# KITTITAS VALLEY FIRE & RESCUE

## KVFR Prevention Conditional Use Permit Comments

Project: 3 BR Custom Cuts

Permit#: CU-23-00001

3200 Wilson Creek Road

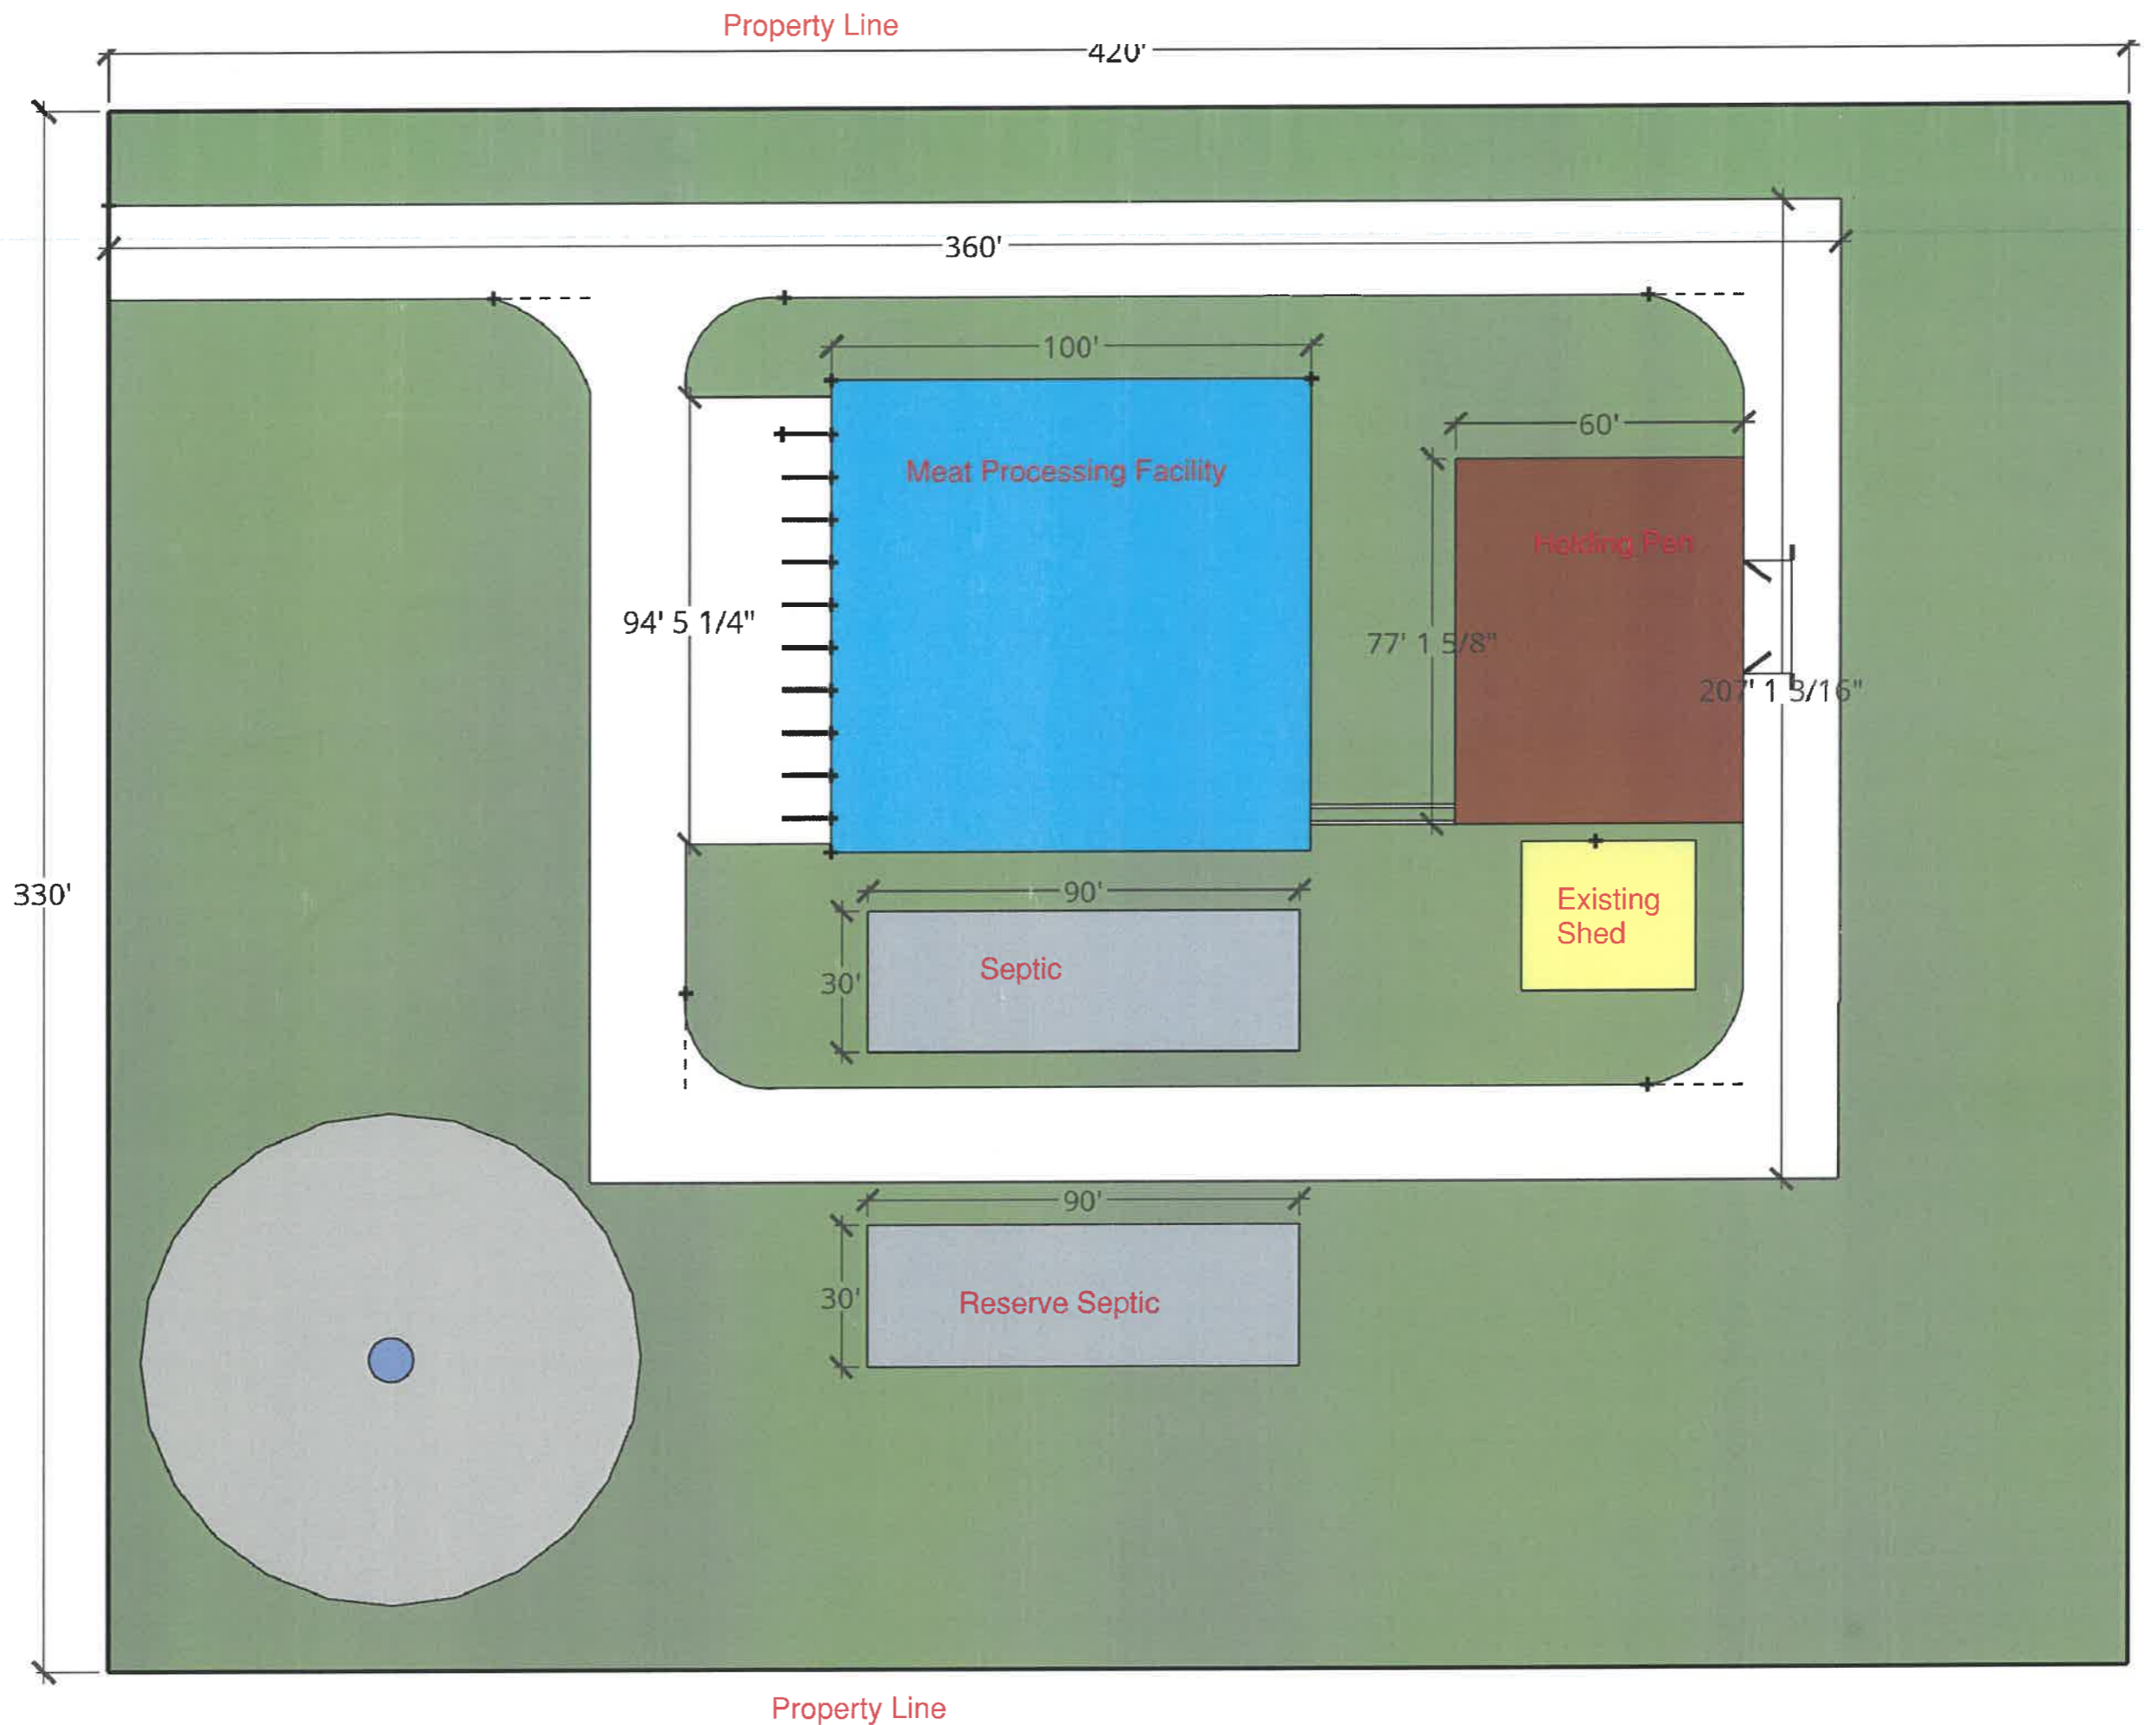
- Fire apparatus access roads exceeding 150' shall be provided with a temporary or permanent turnaround meeting the requirement 2018 IFC Appendix D. The proposed looped drive would meet this requirement.

- Sufficient parking, based on occupancy and to not interfere with fire lanes and building access.
- The IFC Appendix D requires the road be a minimum of 20' wide and capable of supporting an imposed load of at least 75,000 lbs.

- Building would be required to meet IBC and IFC requirements for the occupancy.
- Our standard turning radius is a minimum of 23' inside and 45' outside.
